Consultation Response from KC, Lead Local Flood Authority
2023/90915 adj, 115, Westfield Lane, Wyke, BD12 9LY
Discharge of conditions 6, 7, 8, 9, 10, 11, 12, 13, 14, 15, 16, 18, 19, 20, 21, 22, 23, 25, 27, 28, 30, 31, 32, 33, 34 and 36 of previous permission 2023/91472 for the variation of conditions 9, 11, 12, 22, 23, 25, 27, 29, 30, 33, 34 and 38 of previous outline permission 2020/90436 for the demolition of one dwelling and erection of residential development and associated works with details for access
Date Responded: 07/07/2023. Responding Officer: Martin Stephenson Responding Ref: 1
<u>Previous response by the LLFA</u> Dated 27/07/2020 for application 2020/90436 Dated 10/05/2023 for application 2023/90909 Dated 06/06/2023 for application 2023/90909 Email RE_ 124_008_ 2023_90915 - 115 Westfield Lane_ Wyke – LLFA (MS/CH), dated 03/07/2023. Email RE_ 124_008_ 2023_90915 - 115 Westfield Lane_ Wyke – LLFA (MS/CH), dated 03/07/2023.

Title FLOW CONTROL MANHOLE DETAIL

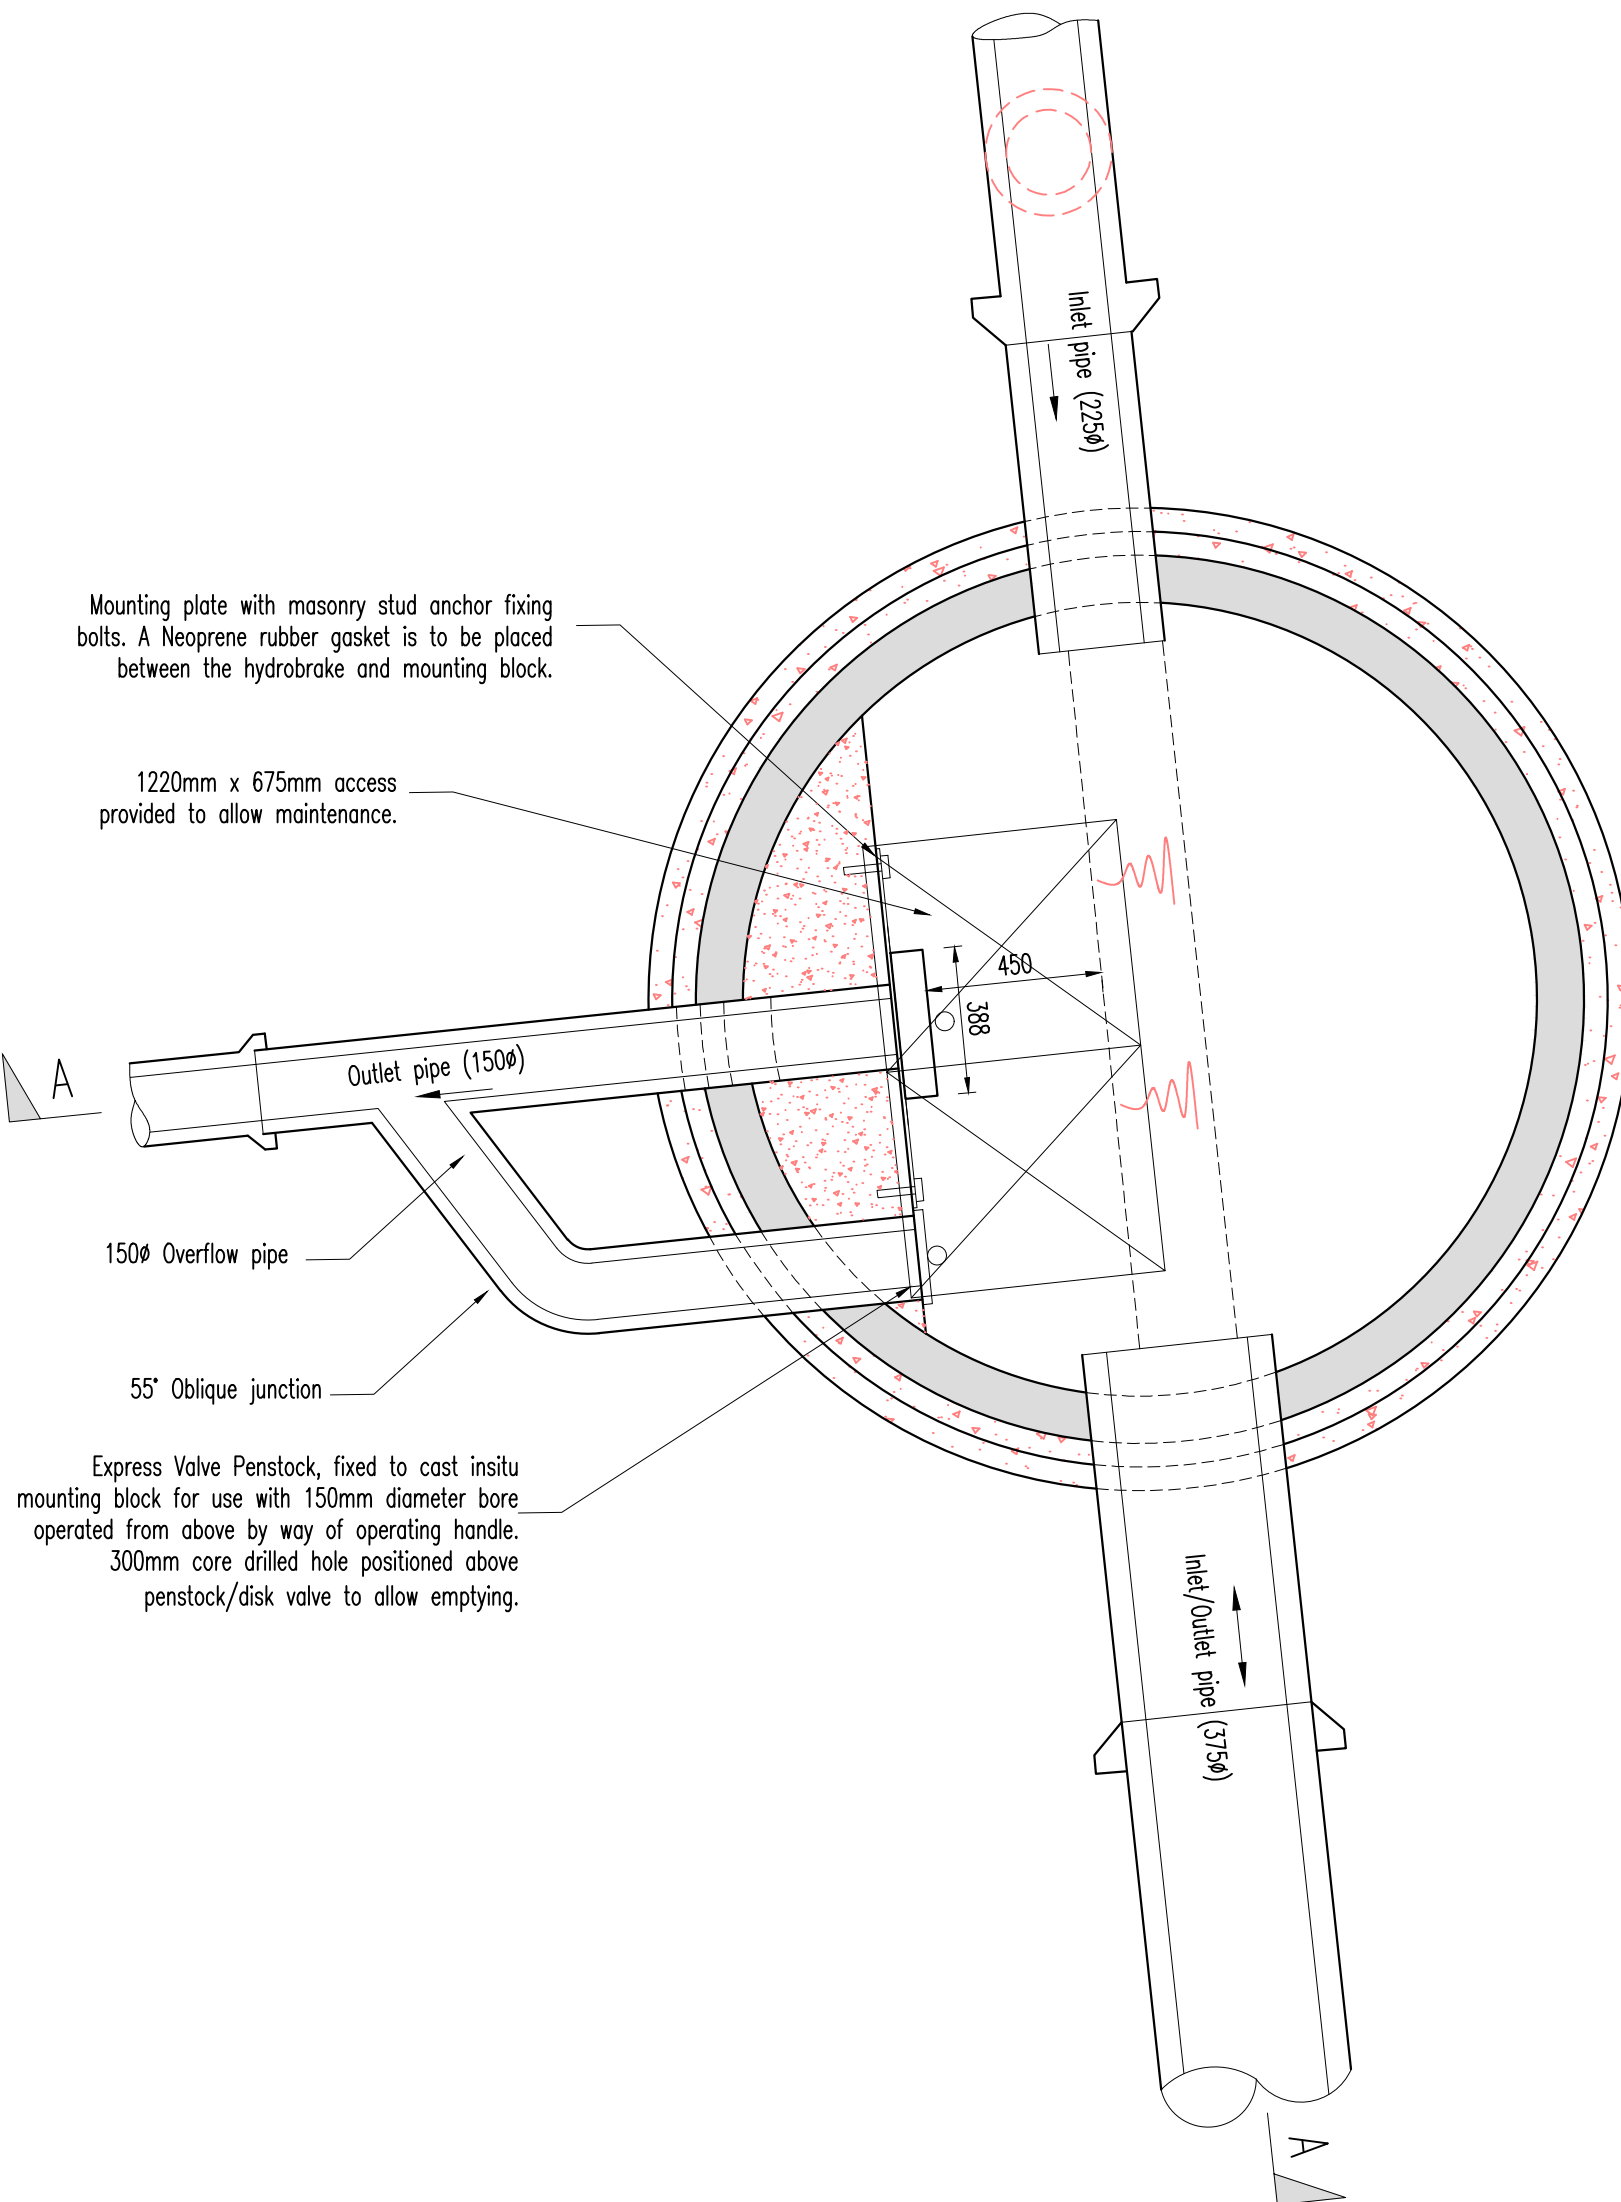
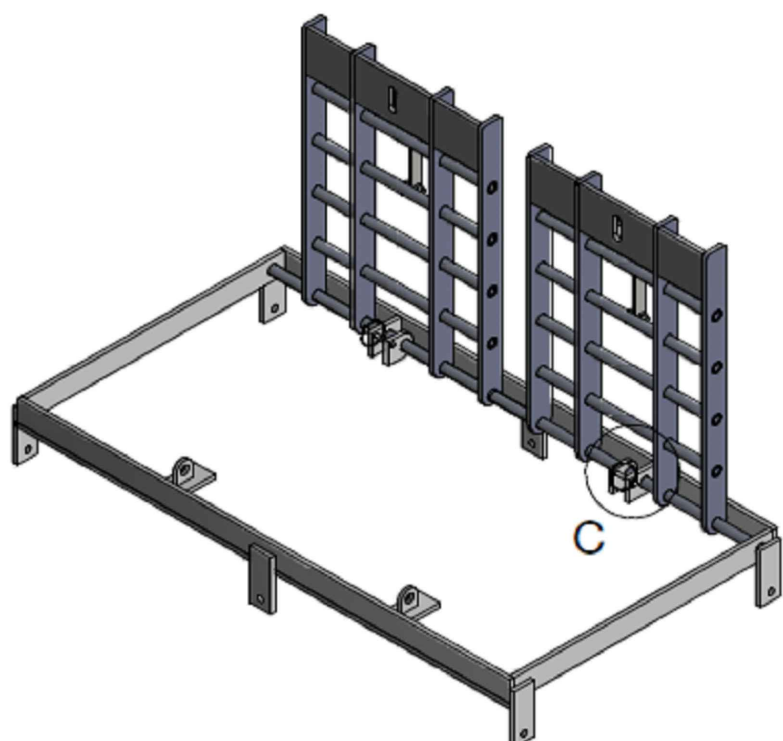
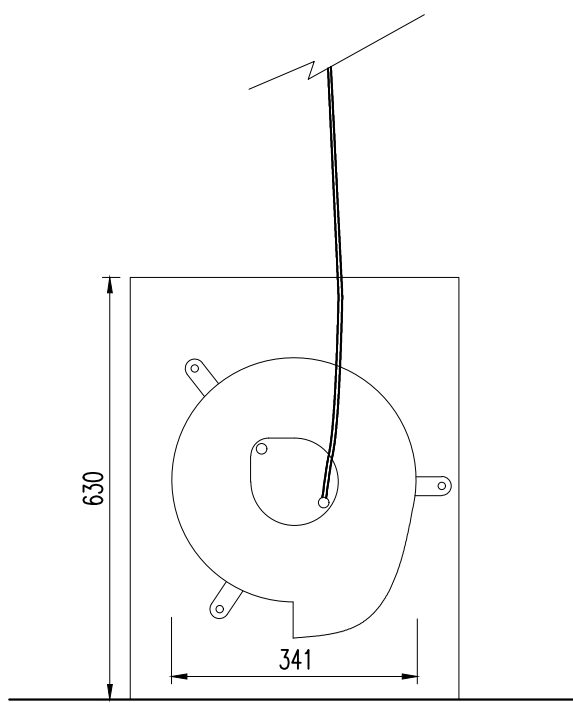
<u>Condition 8</u> Details of the proposed maintenance of the SW drainage system until adoption by Yorkshire Water. Further information regarding the proposed surface water <u>Maintenance Schedule</u> including description of the maintenance activity and planned frequency of inspection for the surface water pipes, MHs, gullies, flow control device, attenuation tank, etc. Therefore Condition 8 <u>cannot</u> be discharged.

Kirklees Flood Management and Drainage as Lead Local Flood Authority requires further information before Condition 8 can be discharged.
